Our Ref: 2026/07/W-LDSP-NPC/AD

Your Ref: EN010168

Date: 12 August 2026

[EN010168] Lime Down Solar Park – Notice of Proposed Change

APFP Regulation: APFP Regulation: 5(2)(a)  
Application Doc no.: APP /6.2  
Drawing no.: Figure 13-11

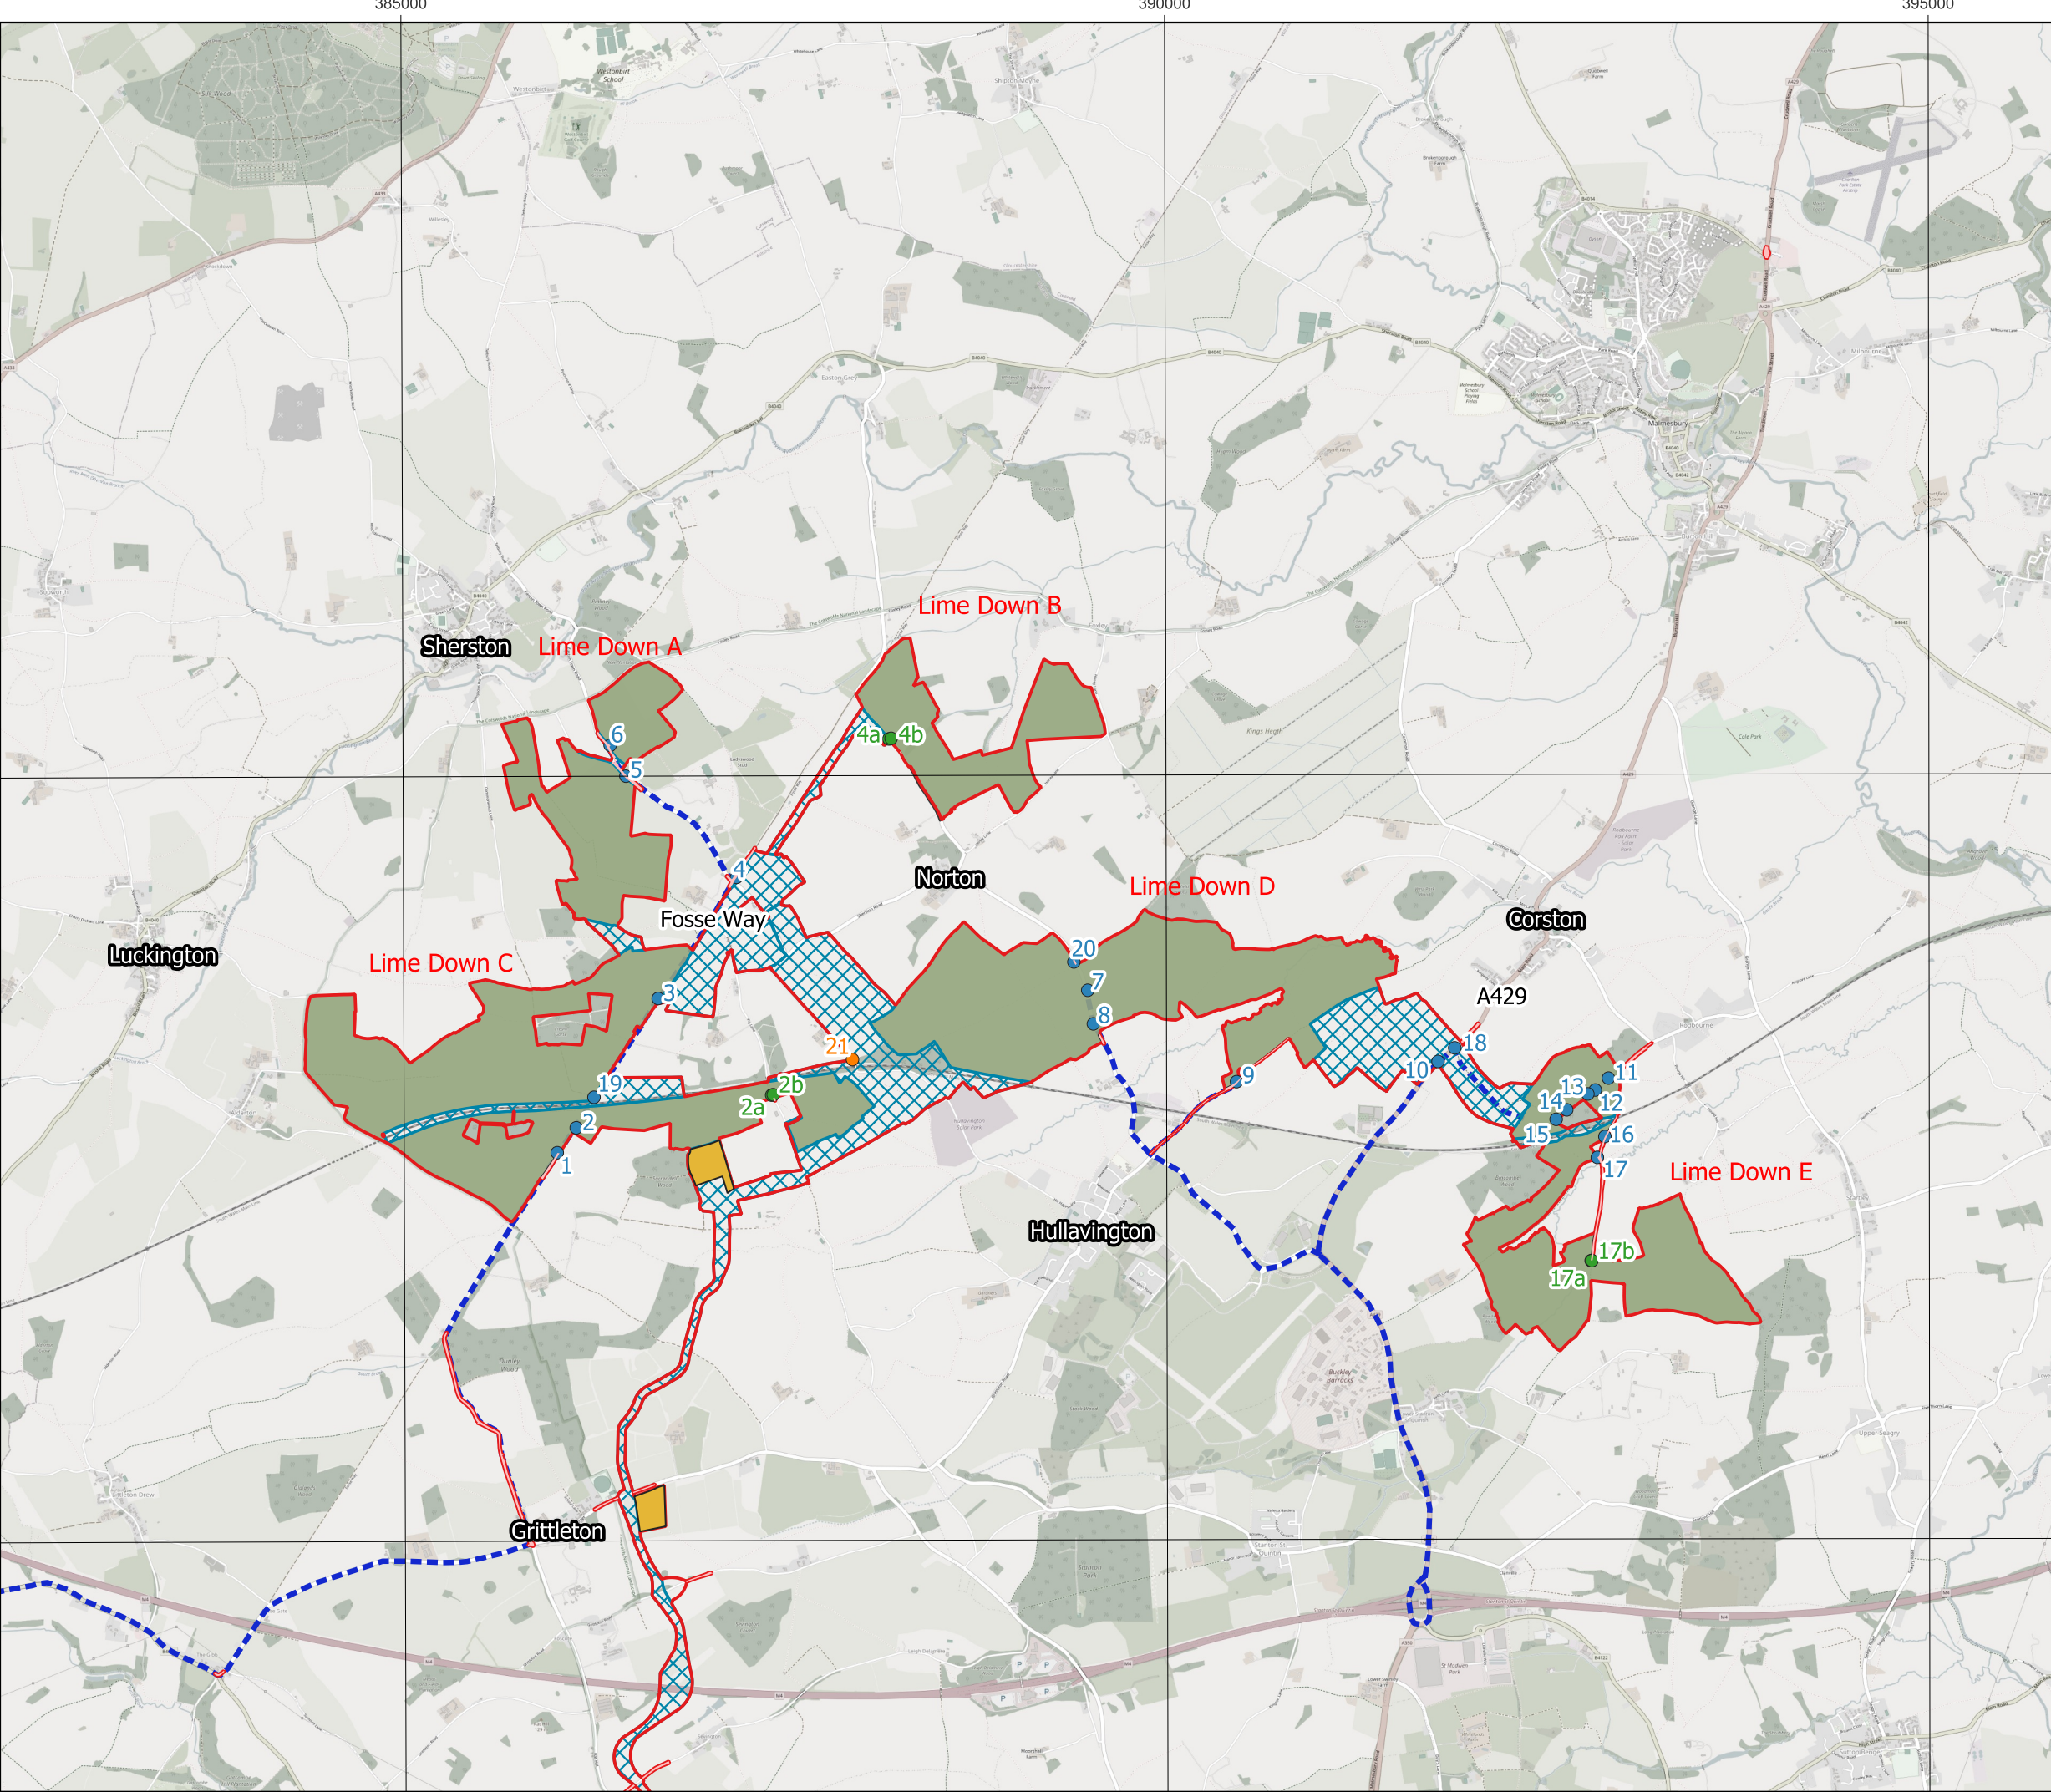
With respect to “Change 1” as outlined in the consultation letter, GCC officers request further information on any changes to access of construction traffic arising from the proposed changes in order limits.

Regarding **“Change 1: An extension of the order limits at Lime Down D to allow the emergency access to connect with public highway.”**

GCC officers note there are two change application areas located on junctions just off the A46 north of M4 Junction 18 that are not included or detailed in document “Change Application and Consultation Report (Revision 1) June 2026”. These are near Doddington Wood and Plough Farm College. Although this section of the A46 is outside Gloucestershire’s boundary, GCC officers would like to request further information on any access changes for construction traffic that can have impacts on the A46 local highway network in Gloucestershire.
